From: [REDACTED]
To: [East Anglia Two](#); [East Anglia ONE North](#)
Subject: Little Moor Farm. PROW Intrusion.
Date: 23 June 2021 15:59:11

[REDACTED]
EA1N and EA2 Onshore substation opposition. PINS REF 20023069 & 20023070 Deadline 12 Submission, 28 June.

Outline Landscape and Ecological Management Strategy, Document Ref 8.7
SPR Ref EAIN-DWF-ENV-REP-IBR-000389 Rev 06.

OLMP Public Right of Way

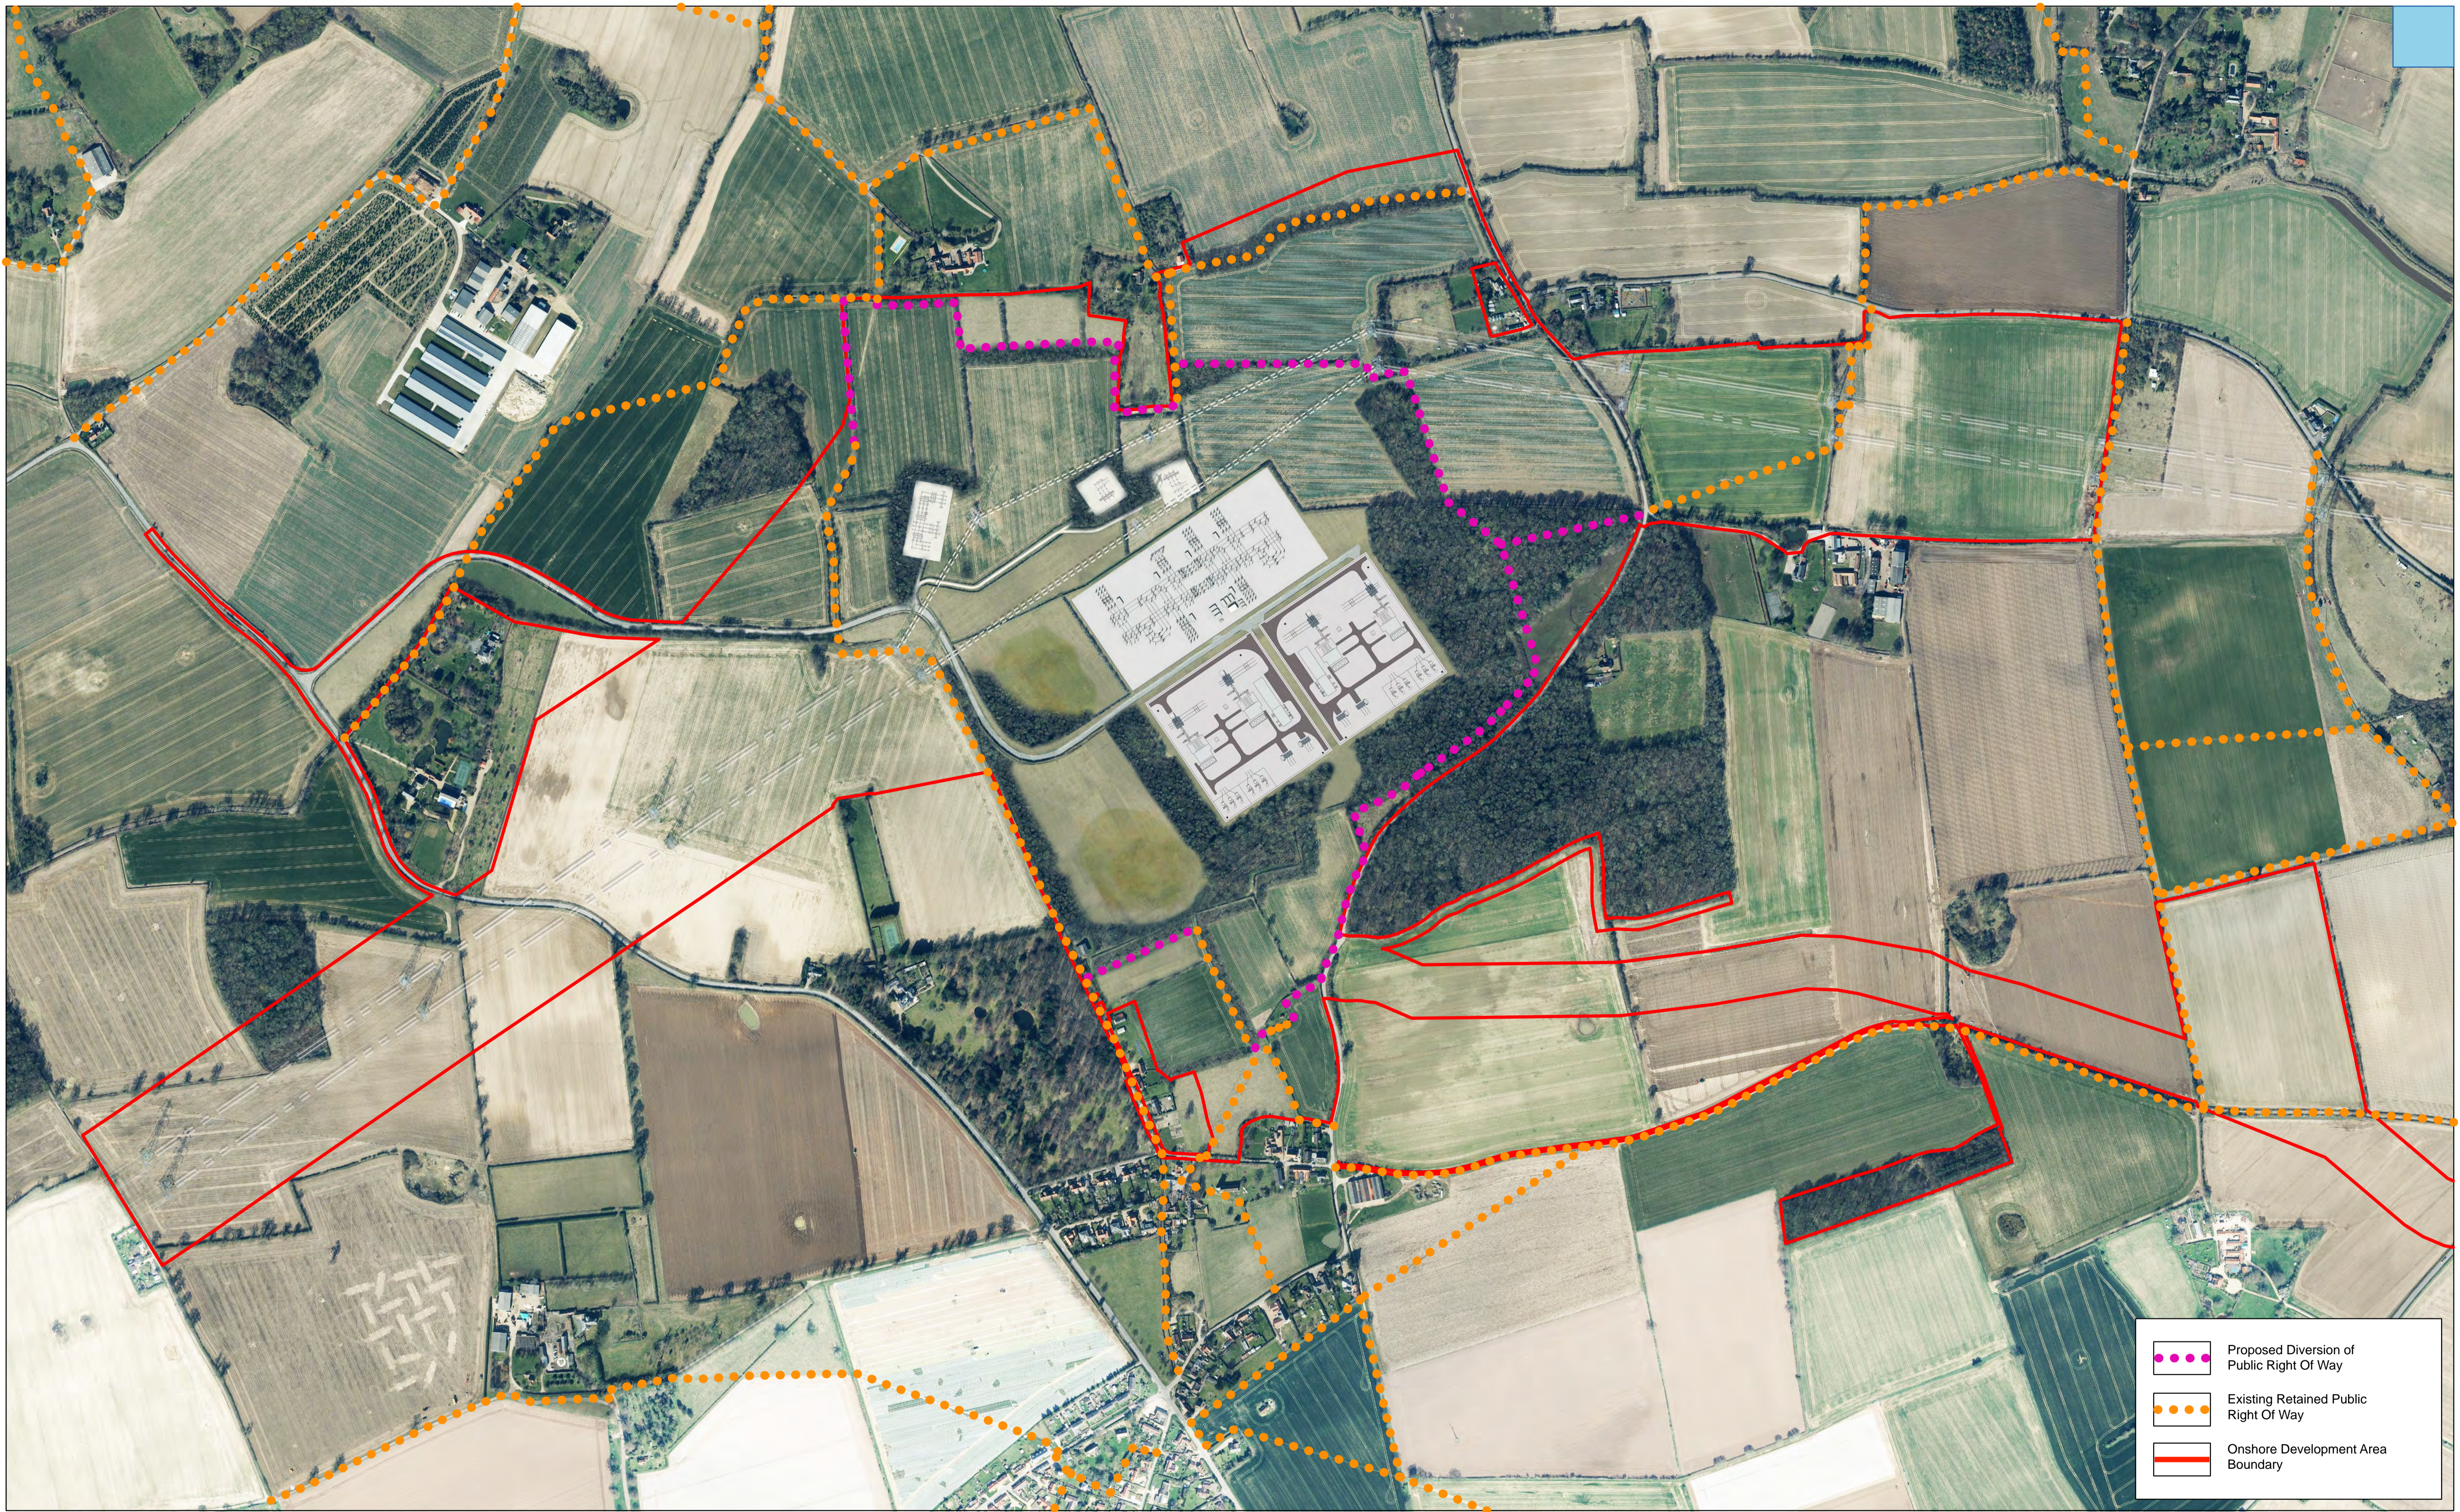
Page 130 of 131 OLMP Public Right of Way Figure 8 dated 11/06/21.

This plan shows the new diverted PROW coming through Laurel Covet, North to Fareacres then West across the field to my boundary halfway down my field. The new route then proceeds south round the perimeter of my field then west across the southern boundary of High House Farm then joins up with the existing PROW which carries on south to Friston. I do not believe this detour around the southern third of my property is required. The new PROW should terminate at my field boundary after coming across from Fareacres then carry on North on the existing PROW. This change increases intrusion on my property boundary line for another third of my property which I don't want. This shortcut has never existed and is not required as once my field boundary is arrived at the public should carry on north on the track that has existed for 500 years not circumnavigate the southern half of my field. Can you please raise this with SPR.
